Our Ref: P/87/11/

Single storey extensions to residential property - Resubmission following planning application P/47/11.

52 East Front Road Pagham

Objection

Project	52 EAST FRONT ROAD, PAGHAM, BOGNOR REGIS WEST SUSSEX PO21 4ST	Drawn	sk	Project	126
For	Mr and Mrs Eysers	Scale	1:100 @ A3		
Title	SOUTH ELEVATION - PROPOSED 2011	Date	25.10.2011	Revision	d
				Drawing No.	P 06

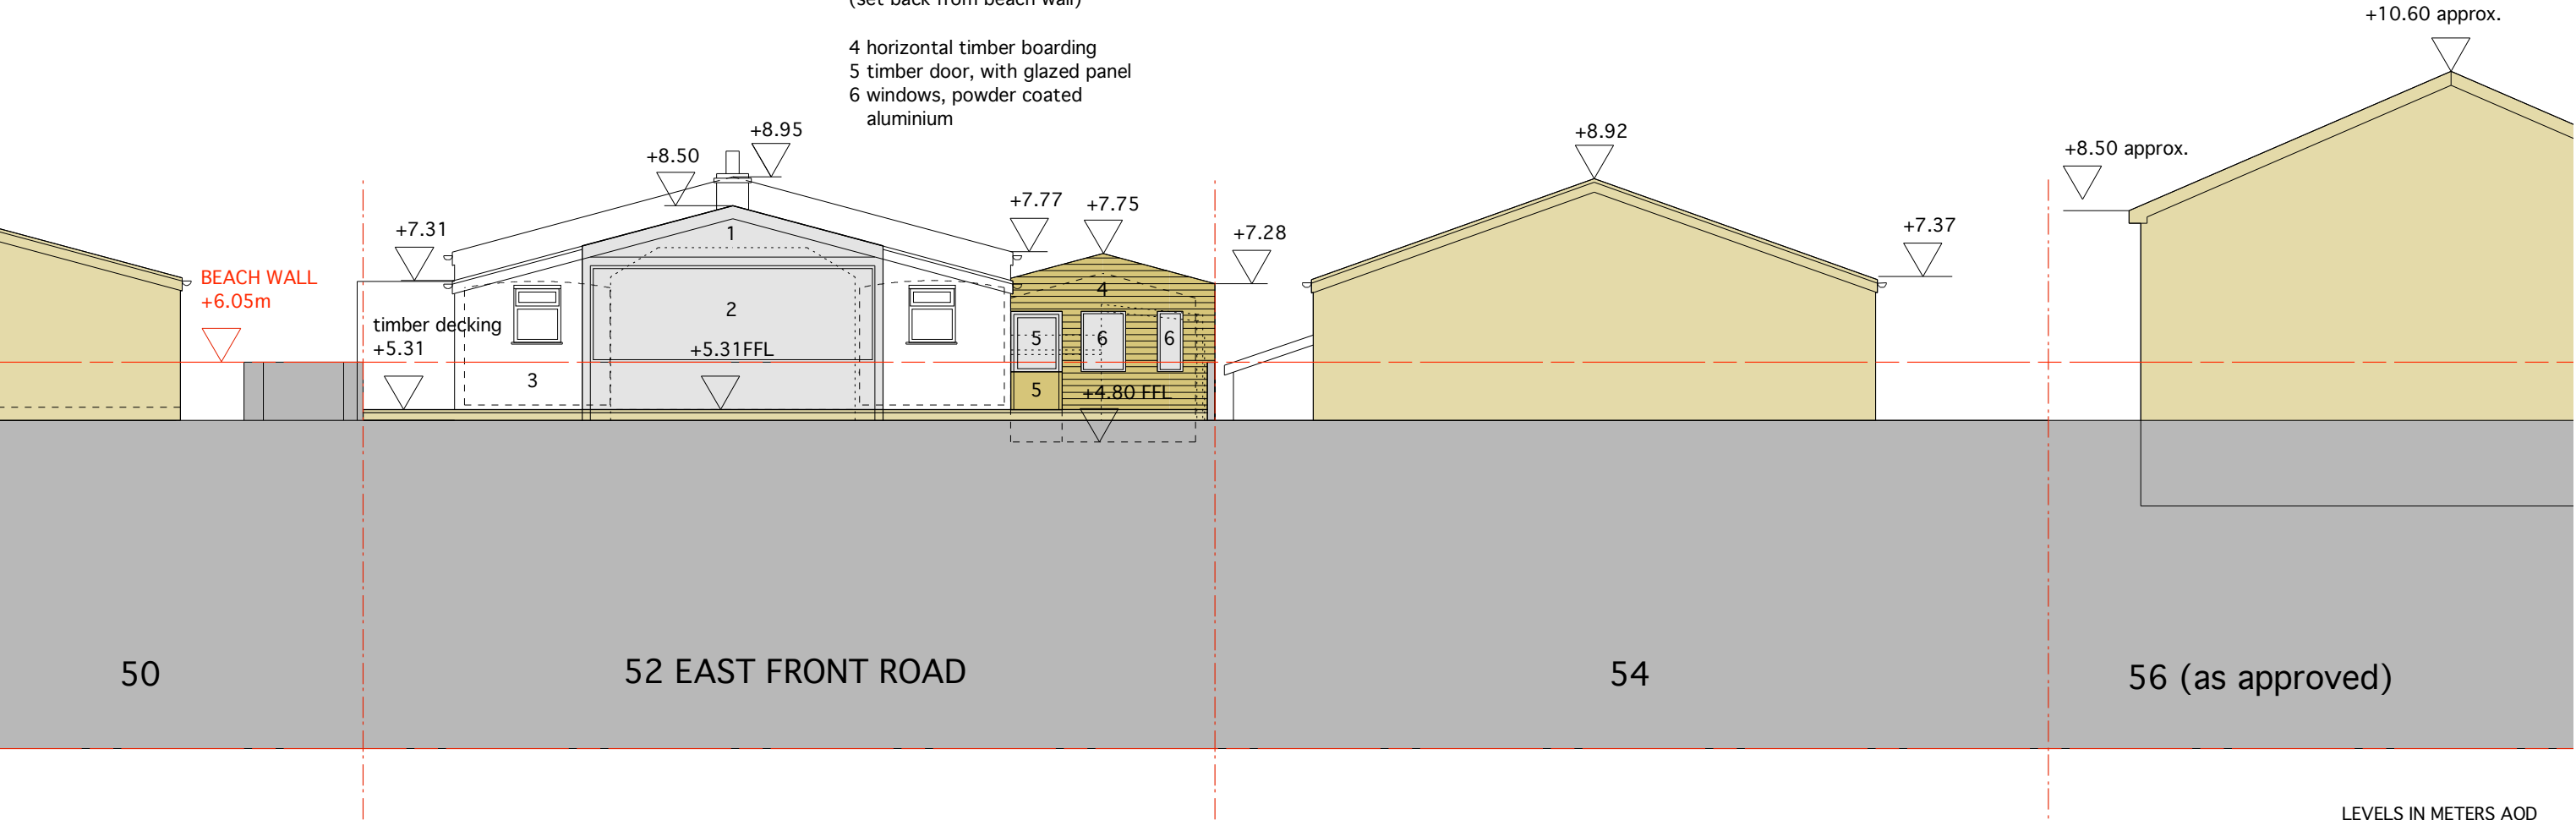
Members noted that the submission before them included various amendments to the previous application, (P/47/11/), in order to address those features which had been subject to objection (hence refusal of consent). These were matters relating to height and bulk of the proposed development, subservience of the garden extension, and amendments to fenestration, (most particularly, roof lights). These were felt to be positive changes, and were duly commended..

Project	52 EAST FRONT ROAD, PAGHAM, BOGNOR REGIS WEST SUSSEX PO21 4ST	Drawn	sk	Project	126
For	Mr and Mrs Eysers	Scale	1:100 @ A3		
Title	EAST ELEVATION AND SECTION A-A - PROPOSED	Date	25.10.2011	Revision	d
					Drawing No. P 07

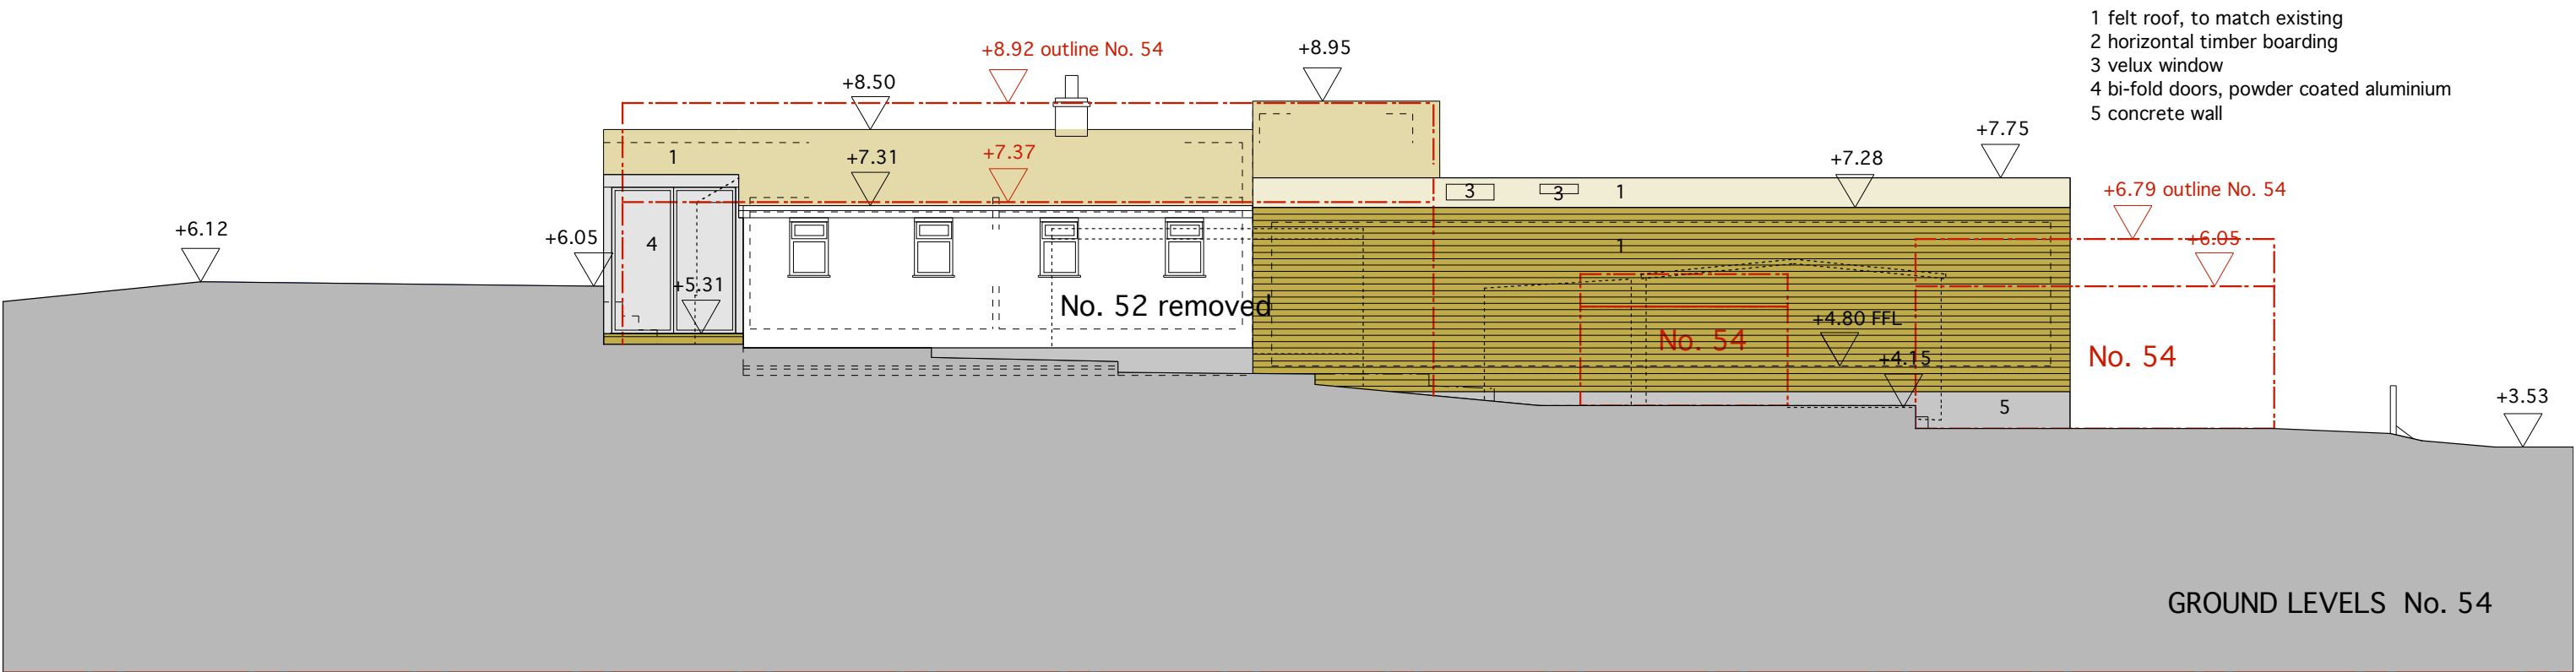
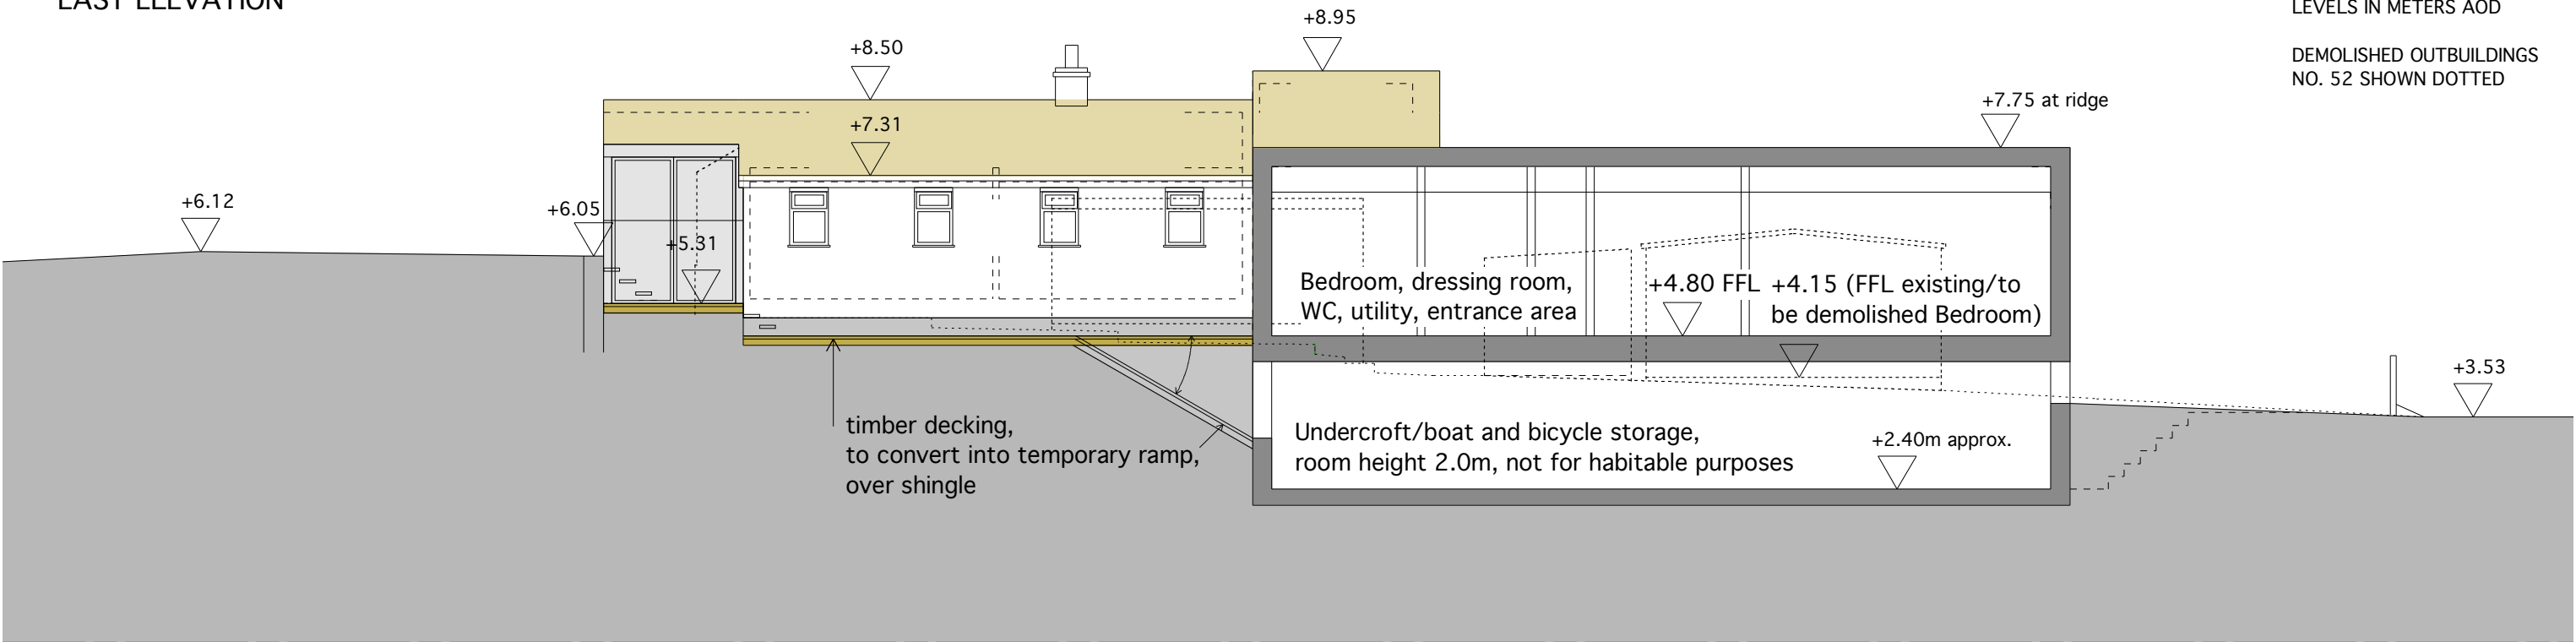
Of greatest concern, however, was the feature of this proposal which has been the subject of consistent objection by the Parish Council; which is the basement or ¿undercroft¿ component of the dwelling. Whether likely to be controlled by conditions in respect of construction and use, it was nevertheless felt to provide a worrying precedent which could lead to a range of irregular developments on the ¿Area of Special Character¿, (ASC).

The significant contour rise from East Front Road to the backshore crest from 3.8 AOD to 6.1 AOD dictates that the ¿undercroft¿ will be the subject of very substantial excavation, raising concerns in respect of ground stability and effects upon adjacent buildings. In this respect the Parish Council is aware of concerns of the Residents Association and the major landowner, Pagham Beach Holdings Ltd.

location, it was felt that potential overtopping in the event of storm-surge, would seriously prejudice both the proposed dwelling, and ground stability adjacent.
